OBJECTION - BR/93/21/PL - 22 Neville Road PO22 8BN

Component: **Proposed Ground Floor Plan**

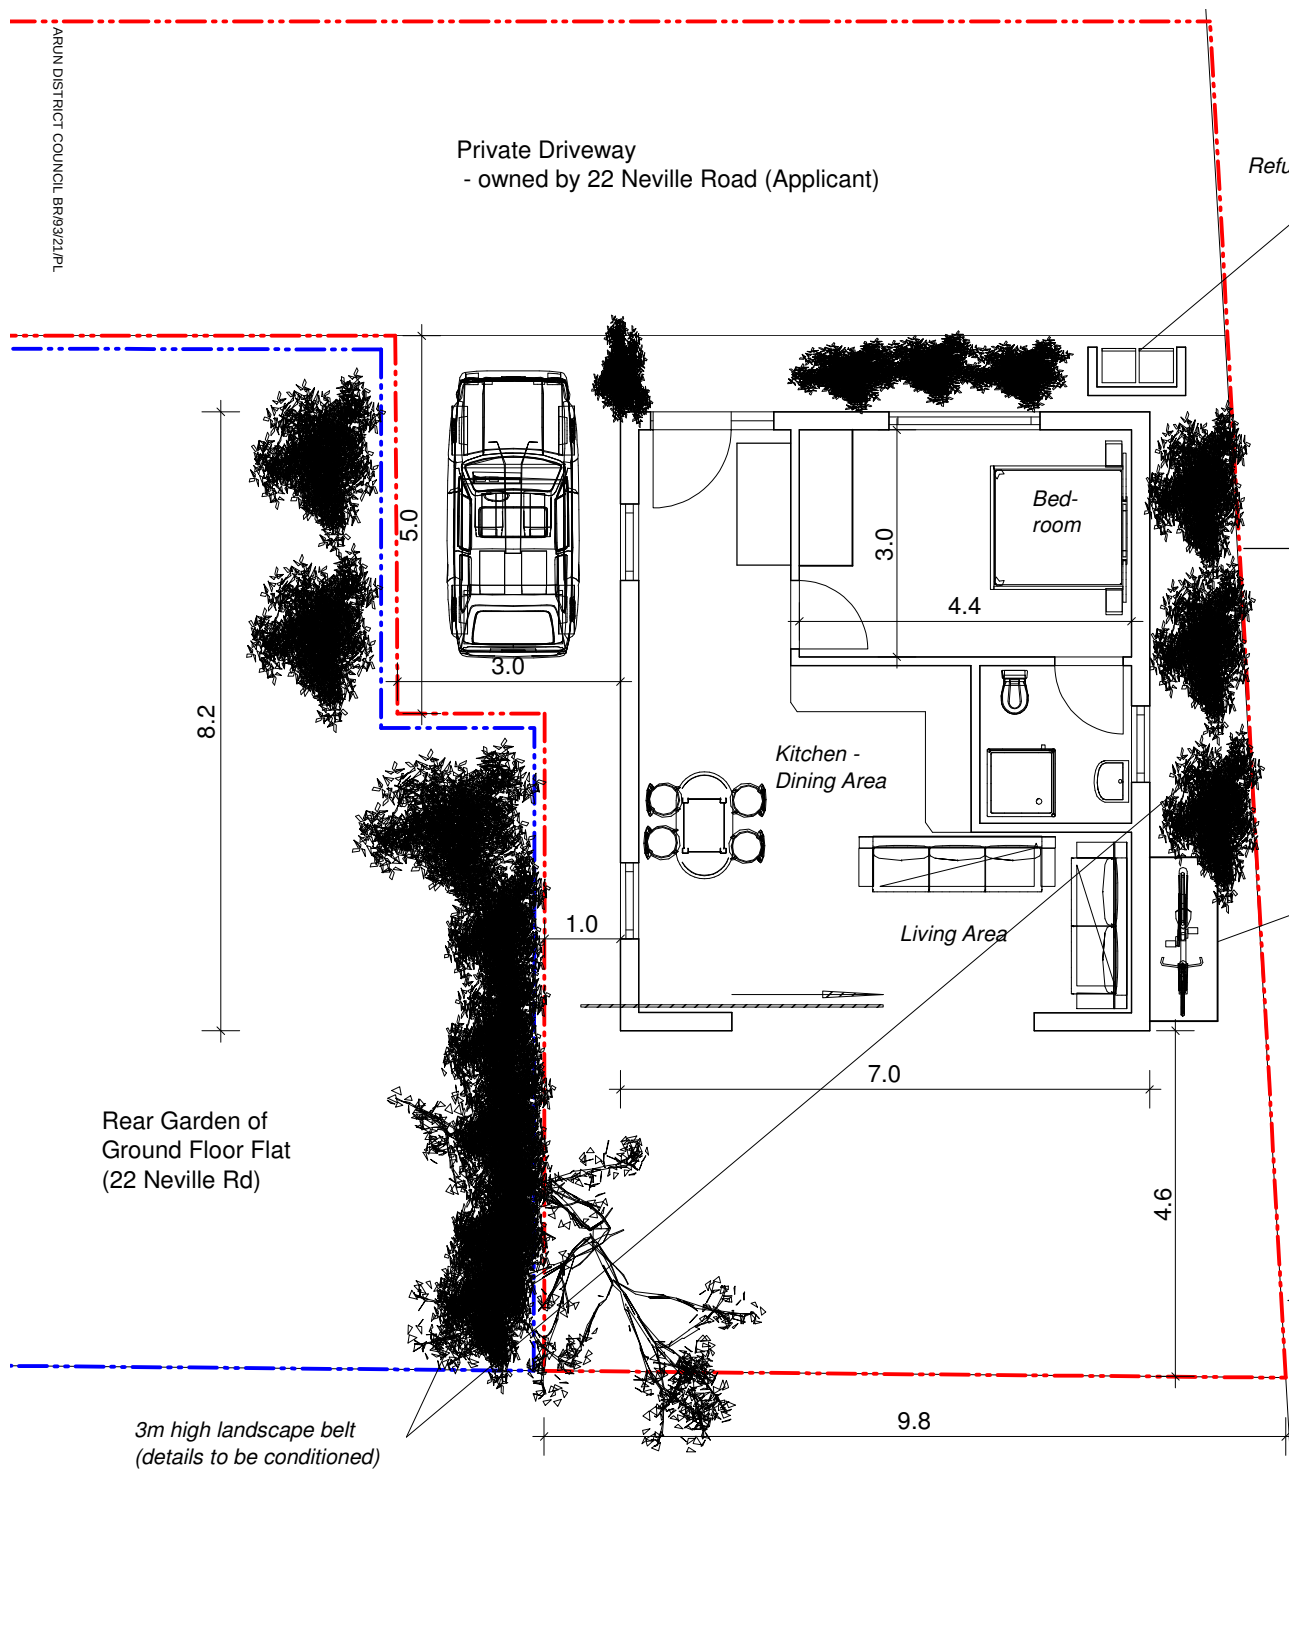
The shared drive with the proposed additional parking will cause conflict with existing neighbours who use the drive to access parking space and a single garage.

13.2.10 The proposal does conform to keeping within the confines of the overall character of suburban back gardens. The proposal does not allow a breathing space between properties. This development will be only four metres narrowing to two meters away from the tenants who inhabit the maisonettes at 22 Neville Road. The residents are hemmed in by an enclosure of a two-metre fencing which detracts visually, in the attempt to maximise land for development.

The form shape and design are of a sub-standard quality which is presented by a flat-roofed brick block construction punctuated by windows of obscured glass and patio windows with a garden depth of 4.6 metres. The proposal contravenes Arun's Design Guide which specifically mentions that developers should avoid building on back gardens. In this case the proposal does not measure up to the recommended 10.5 metres.

The reduction of congestion and the reduction of car use is contradicted by the inclusion of one car parking space when there will be potentially two occupants of the proposed building. The second car will need to be parked on a street already burdened by car parking on a busy road used as a cut through to avoid the A259.

SPG states that gardens should have a minimum depth of 10.5 metres of space. The applicants proposal subverts this guidance by the plan to build on the two gardens used by the tenants at 22 Neville Road, who have no opportunity of growing their own produce, providing a minimal amount of usable space for the proposed dwelling. The proposed dwelling does not have a proportionate amount of rear garden.

Component: Proposed Roof Plan

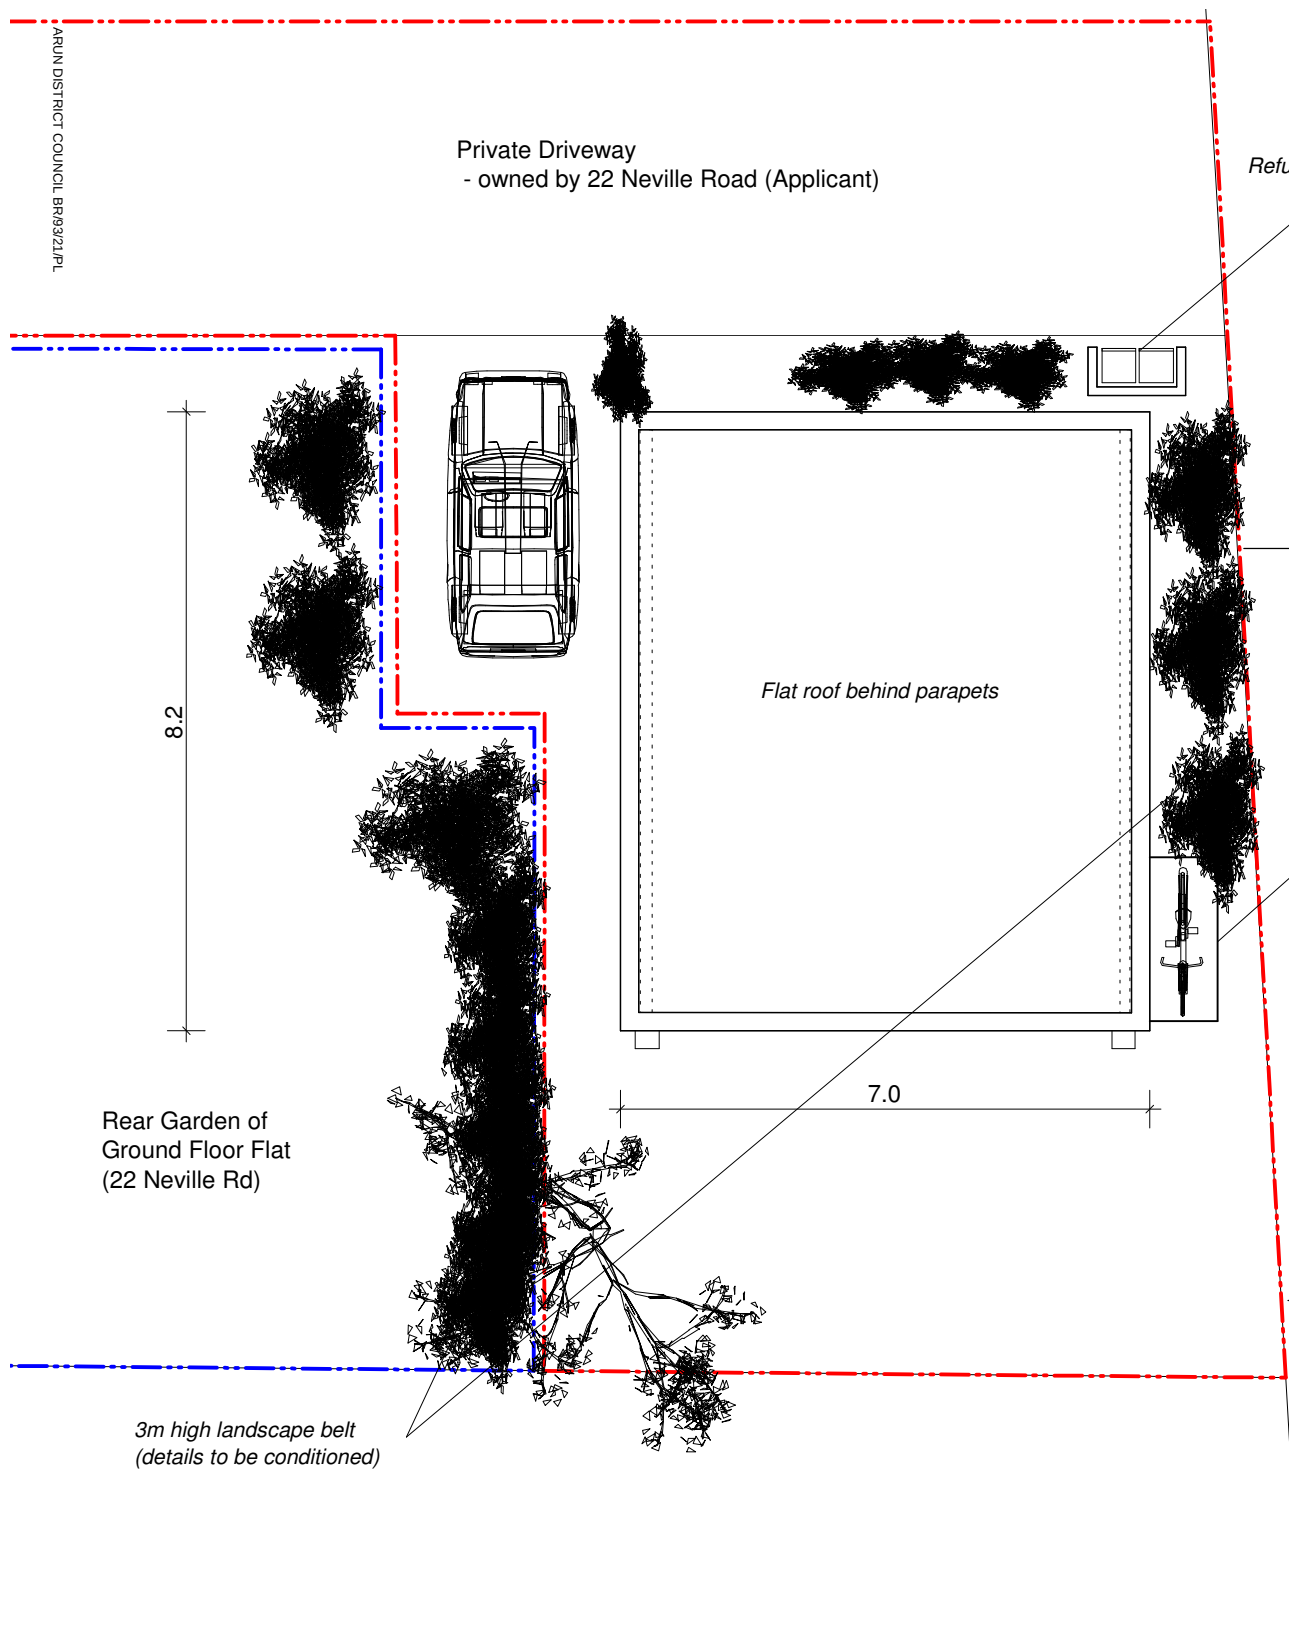
The proposed construction is of poor design, a badly designed flat-roof brick box on a restricted site which is at variance with the Adopted Local Plan which protects and enhances the local environment, including wildlife habitats, trees and woodland parks and gardens.

The proposal concretises garden space. It increases run off from the flat roof of the proposed dwelling and the concretisation of the overall footprint causing further run off which contributes to stress on the drainage systems and flash flooding.
